CITY OF ALBUQUERQUE

RE: **Drainage Deficiency/Recommendation Notice- Letter Sent
3830 Singer Blvd NE, Albuquerque, NM 87109**

**RE: Drainage Deficiency/Recommendation Notice
3830 Singer Blvd NE, Albuquerque, NM 87109**

The purpose of this letter is to inform you of drainage deficiencies on the western edge of your property located at 3840 Singer Blvd NE. The City-approved grading plan for this property shows a 6" curb along the west property line which conveys stormwater south to a steel top culvert and out onto Commons Ave.

LOT 22A Jefferson Commons Industrial Park As-Built Information

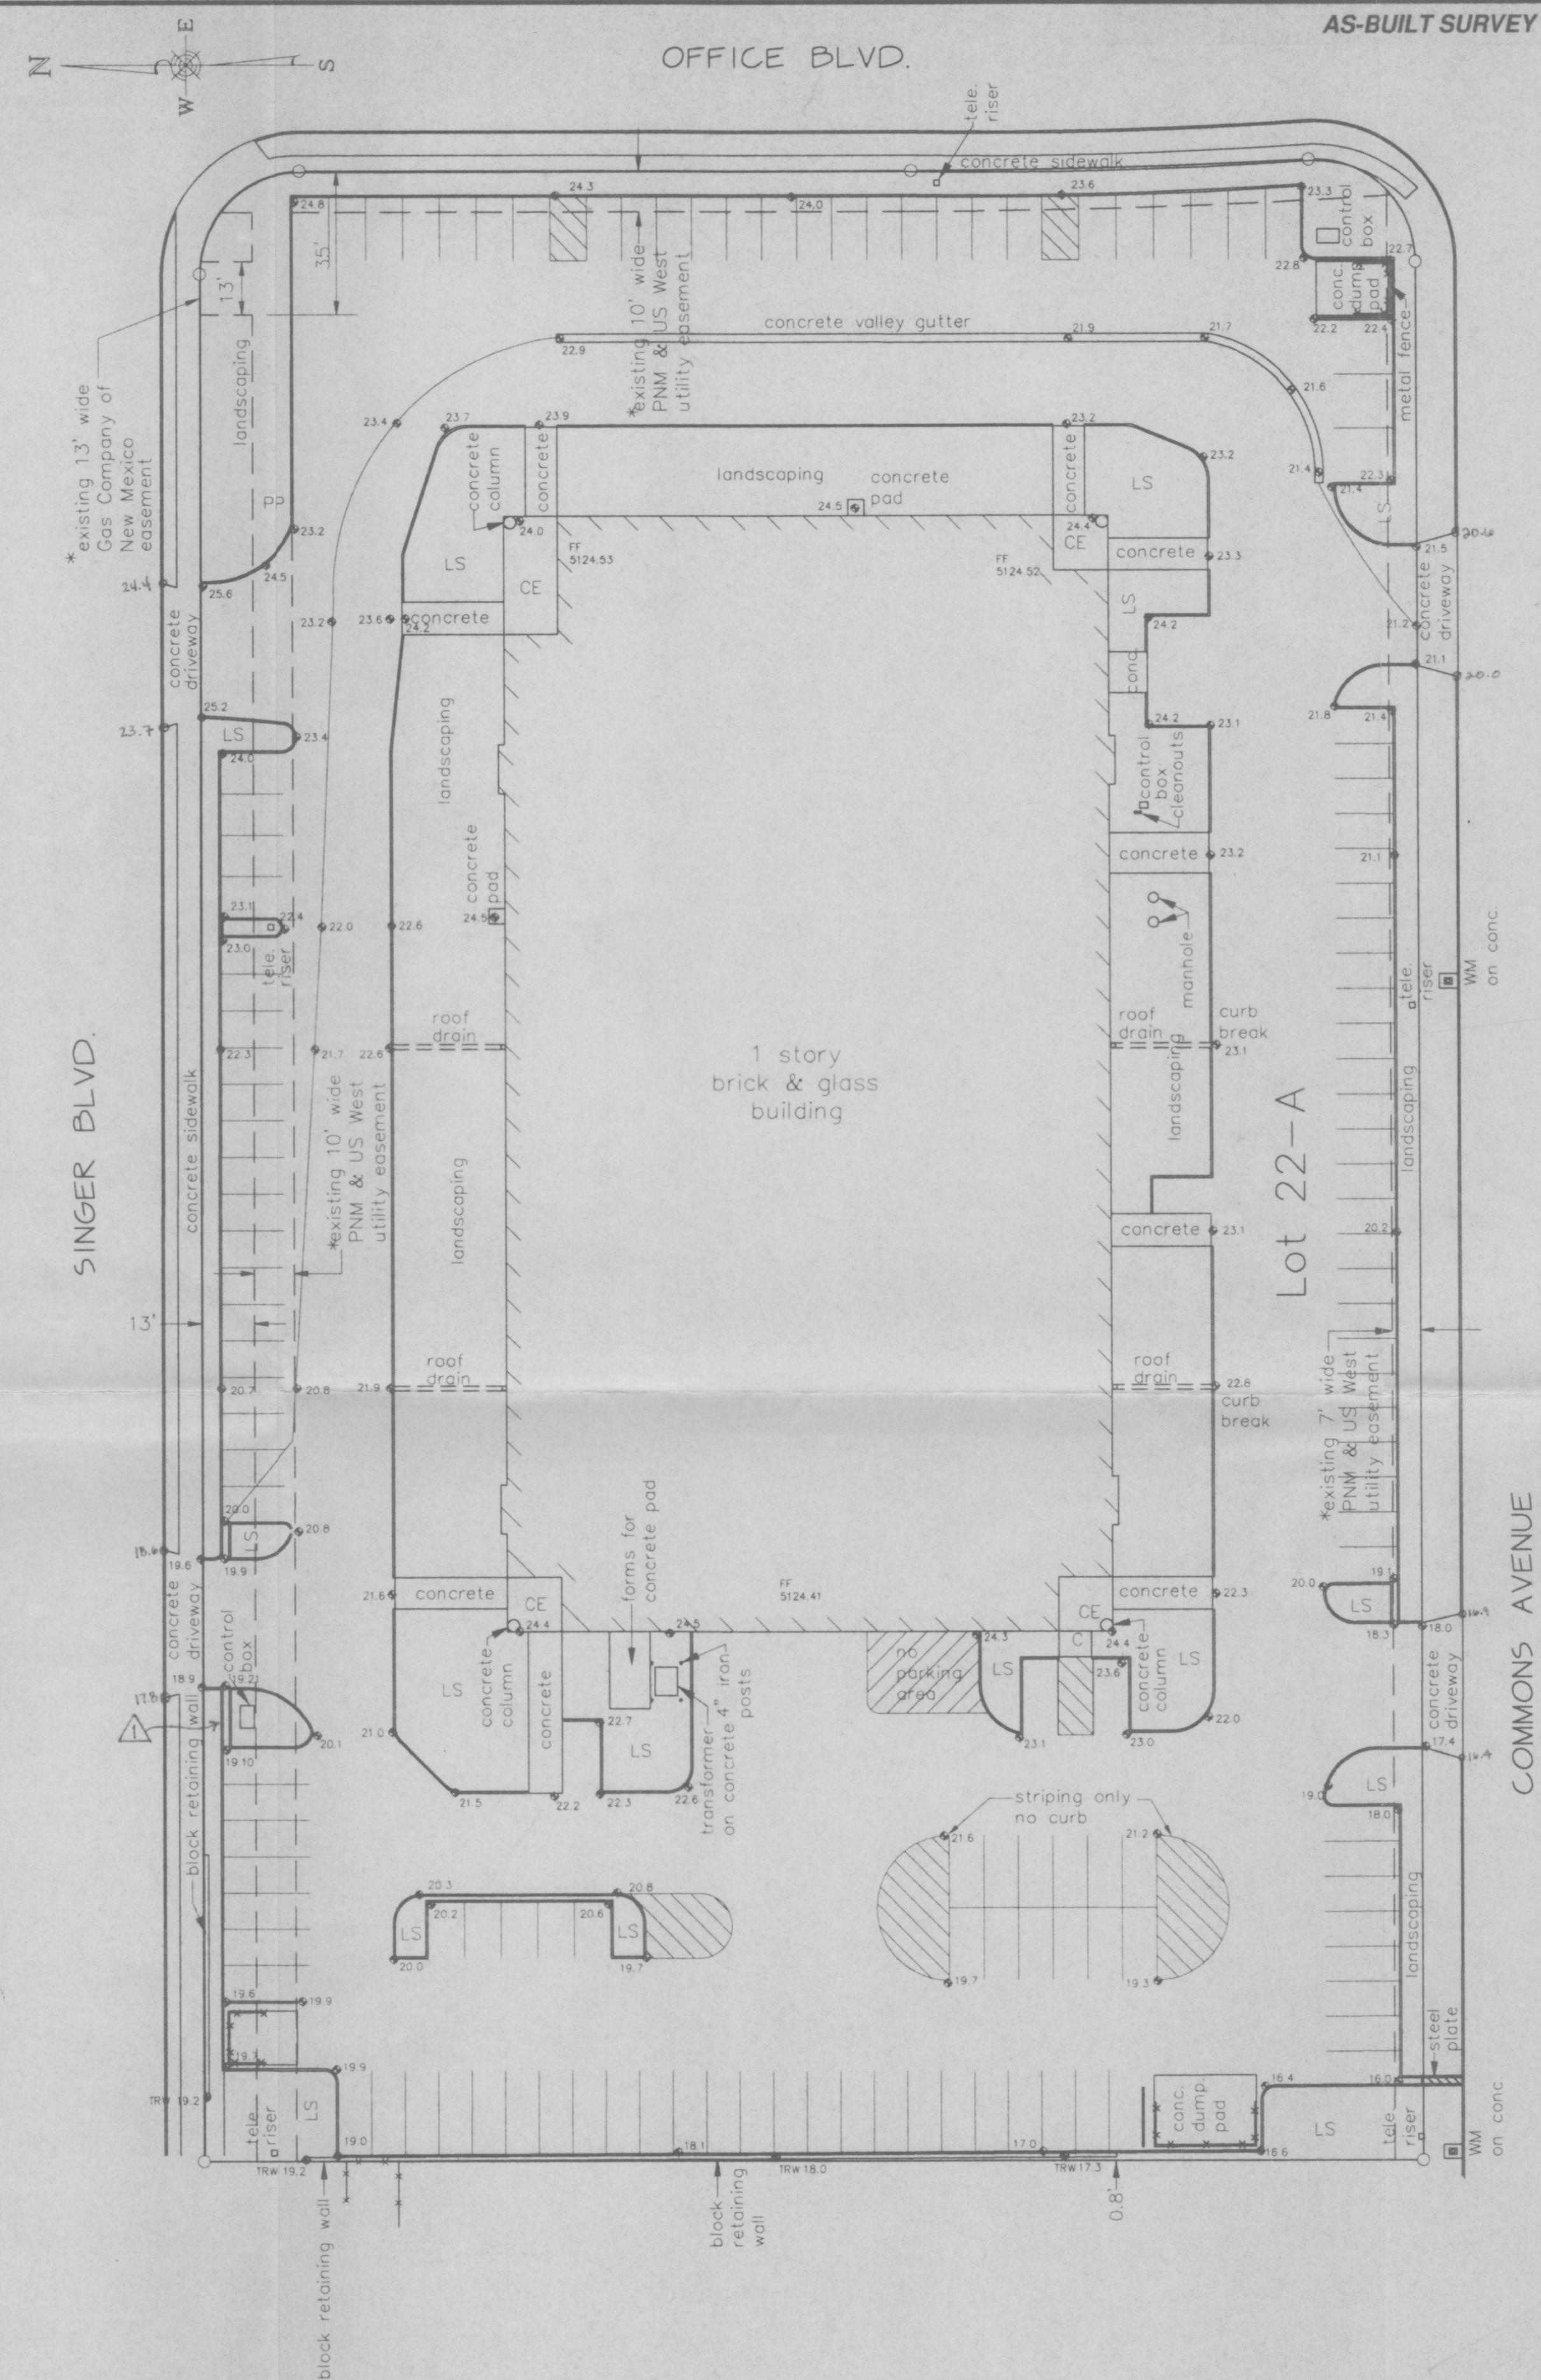
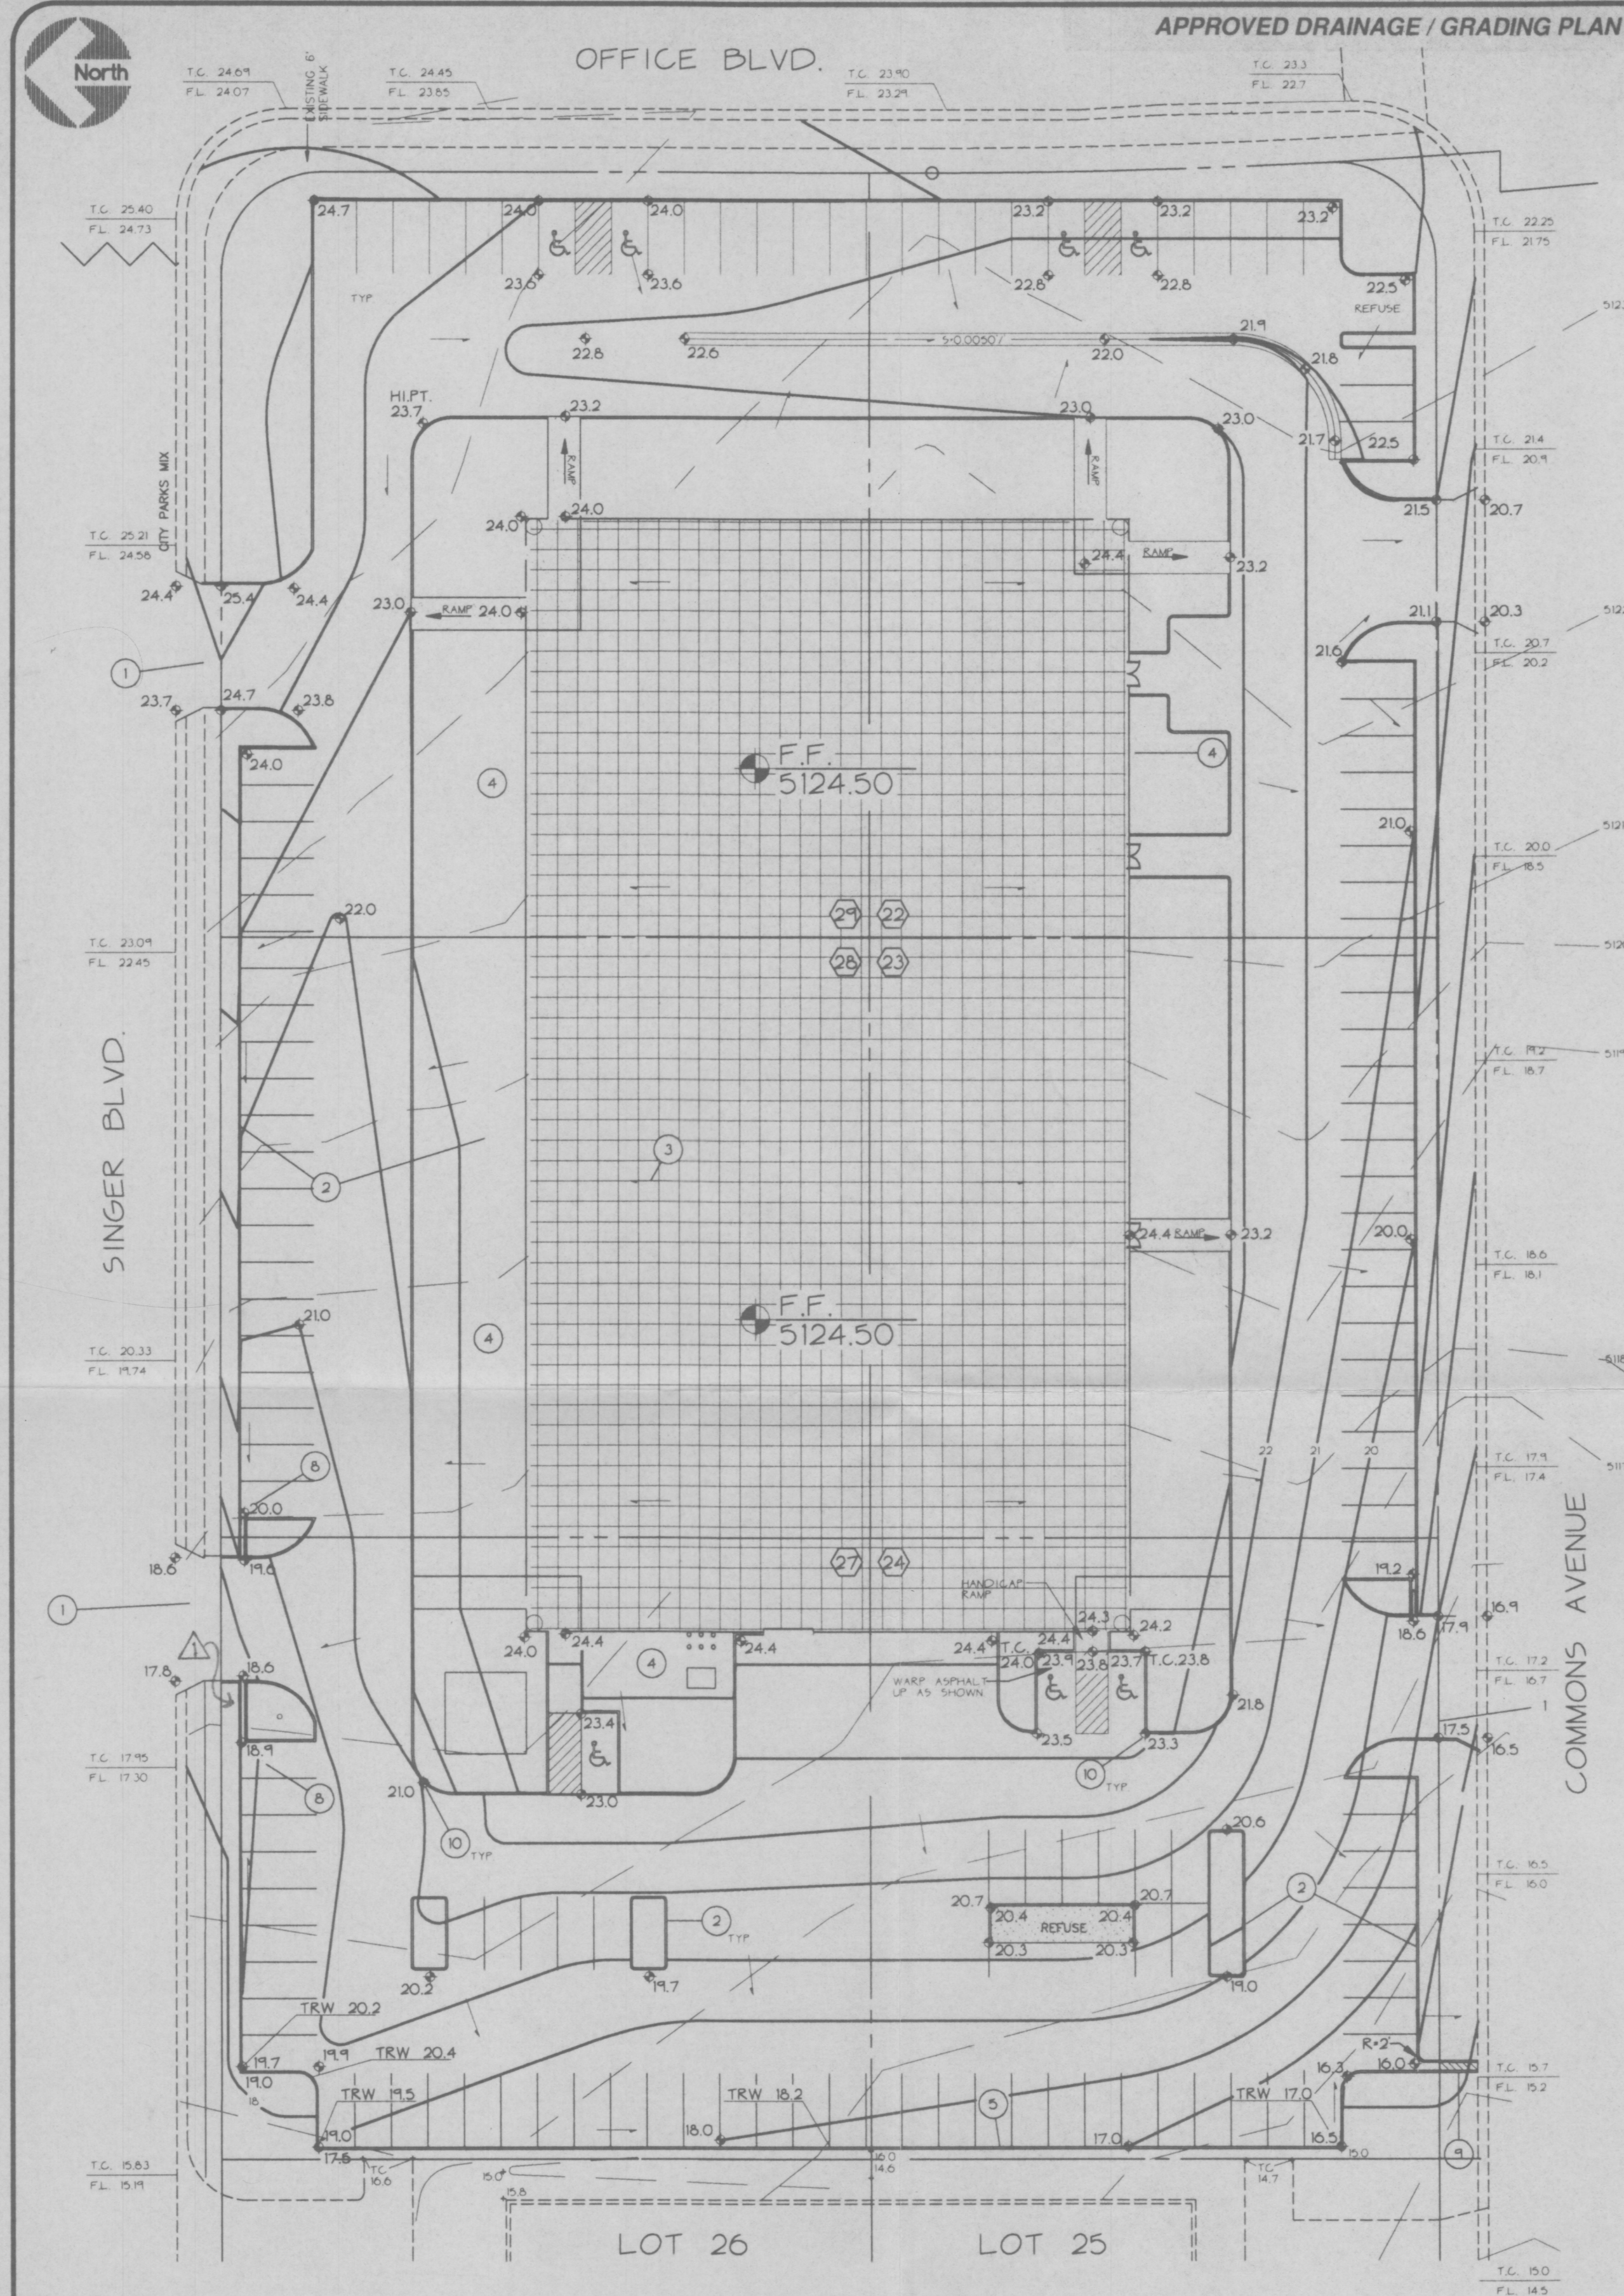
1. The concrete curb is has settled and undermined along much of it length, allowing stormwater to pass freely to the west; the 6" height is also not high enough to contain flows during especially heavy rainstorms. This curb should be replaced with a higher curb such as header curb (CoA Standard Drawing 2415B) along its entire length so stormwater can be forced south the Commons as originally intended:

2. The shipping containers placed along the property line should be pulled back ~2' from the curb so the flowpath is not obstructed; the bottom 12" of fencing should also be removed from the flowpath. These recently placed items appear to partly obstruct the flow path to the south:
